# Rezoning Transportation Analysis

Petition Number: #2022-105

## Revision Log:

| Date     | Description        |
|----------|--------------------|
| 12-19-23 | Fourth Review (IW) |

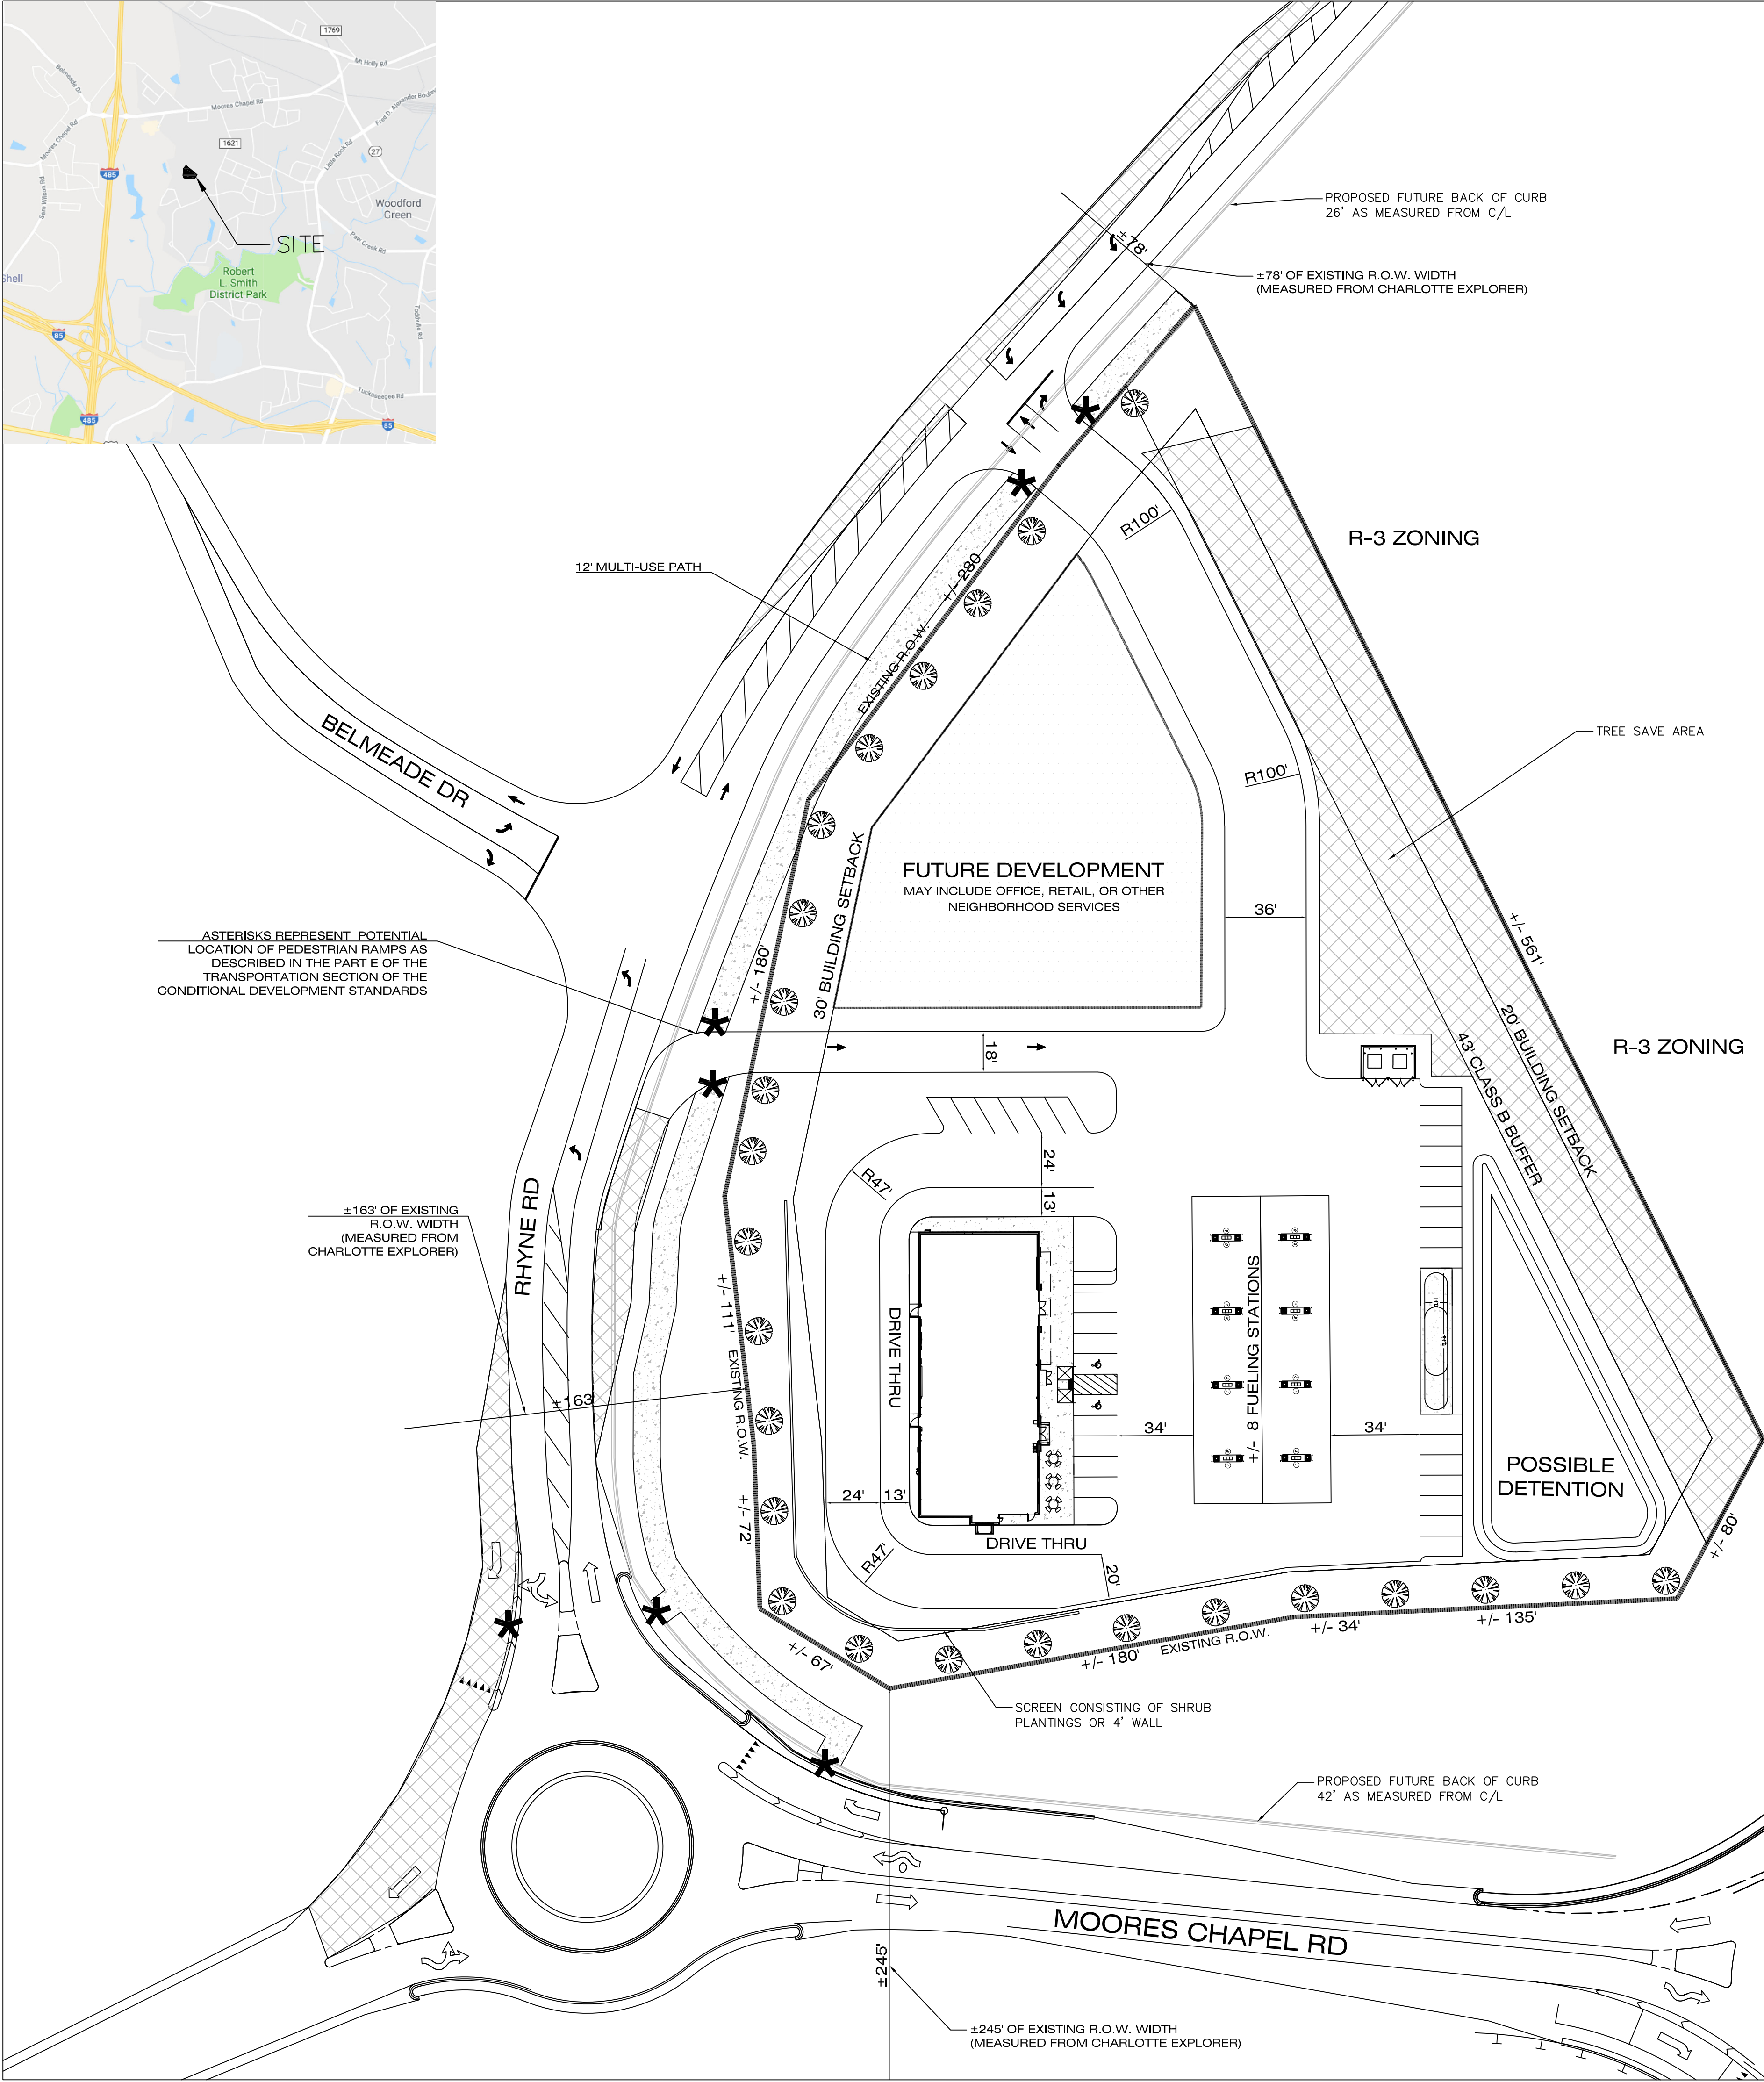
- Outstanding Comment** Revise site plan and conditional note(s) to provide 12-foot multi-use path and 8-foot planting strip along all public road frontages (Moores Chapel Road, Rhyne Road, Belmeade Drive). Revise the ramp locations and conditional note Transportation Note E to include the additional ramps that will be required. Provide SUE located 2-feet behind sidewalk if located outside of the ROW. Add conditional note to coordinate Control of Access Break with NCDOT for proposed multi-use path along

- Outstanding Comment** Revise site plan and conditional notes to provide curb and gutter along the public roads that front the proposed tree save parcel. The minimum distance to the back of curb and gutter is 19-feet from the centerline of Rhyne Road and 30-feet from the centerline of Moore's Chapel Road.

**Clarifying Comment from 12/22/2022:** Label and dimension streetscape along all public road frontages (12-foot multi-use path and 8-foot planting strip). Revise ramp locations as shown above and update conditional note to incorporate additional ramps. Provide SUE located 2-feet behind sidewalk if located outside of the ROW. Add conditional note to coordinate Control of Access Break with NCDOT for proposed multi-use path along Moores Chapel Road.

**Clarifying Comment from 2/22/2023:** If the tree save area to the west of Rhyne Road was removed from the rezoning, MUP will no longer be required on the west side of Rhyne Road – clarify whether parcel west of Rhyne Road is included in the petition. The MUP along Moores Chapel is required for the rezoning petition. If NCDOT does not allow the MUP during site plan permitting, it will not be required to be constructed. Curb and gutter required for all public street frontages – label, dimension, and commit to curb and gutter and MUP in conditional notes.
